## Fire Marshal Division

**RE: JR Mart**  
**920 S. Main St.**  
**Lillington, NC 27546**

**Application Number FMFW2002-0006**

PYRO CHEM KITCHEN KNIGHT II FIRE SUPPRESSION SYSTEM

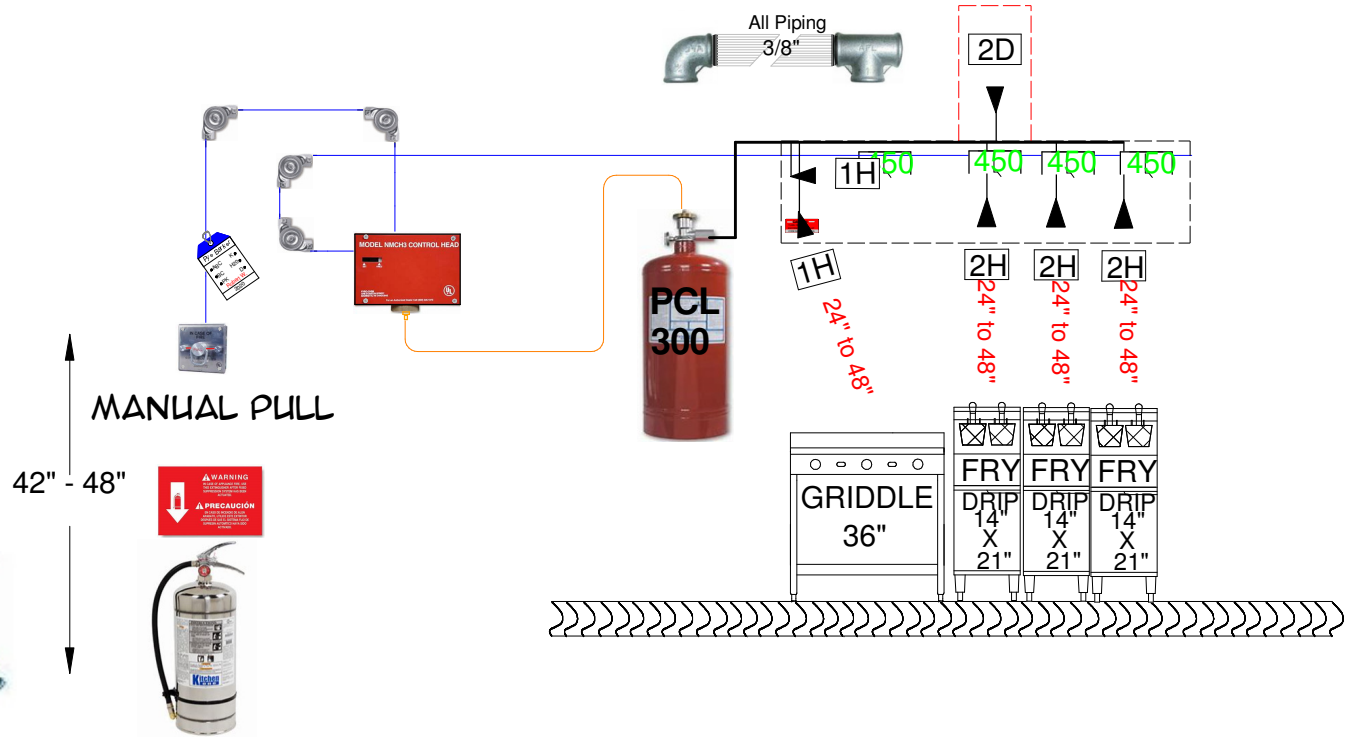
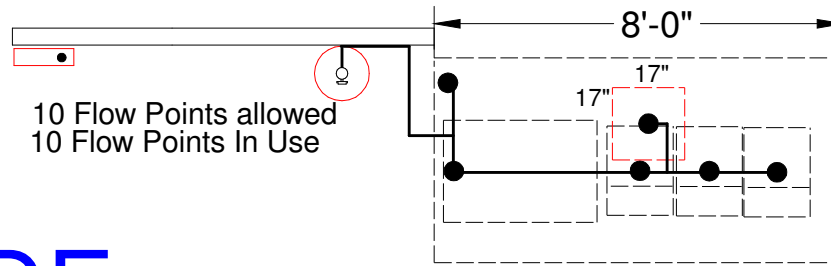
- **Commercial cooking equipment.**
  - Portable fire extinguishers shall be provided within a 30-foot (9144 mm) travel distance of commercial-type cooking equipment. Cooking equipment involving vegetable or animal oils and fats shall be protected by a Class K rated portable extinguisher.

- **Manual system operation**
  - A manual actuation device shall be located at or near a means of egress from the cooking area, a minimum of 10 feet (3048 mm) and a maximum of 20 feet (6096 mm) from the kitchen exhaust system. The manual actuation device shall be located a minimum of 4.5 feet (1372 mm) and a

maximum of 5 feet (1524 mm) above the floor. The manual actuation shall require a maximum force of 40 pounds (178 N) and a maximum movement of 14 inches (356 mm) to actuate the fire suppression system.

- The actuation of the fire suppression system shall automatically shut down the fuel or electrical power supply to the cooking equipment. The fuel and electrical supply reset shall be manual.
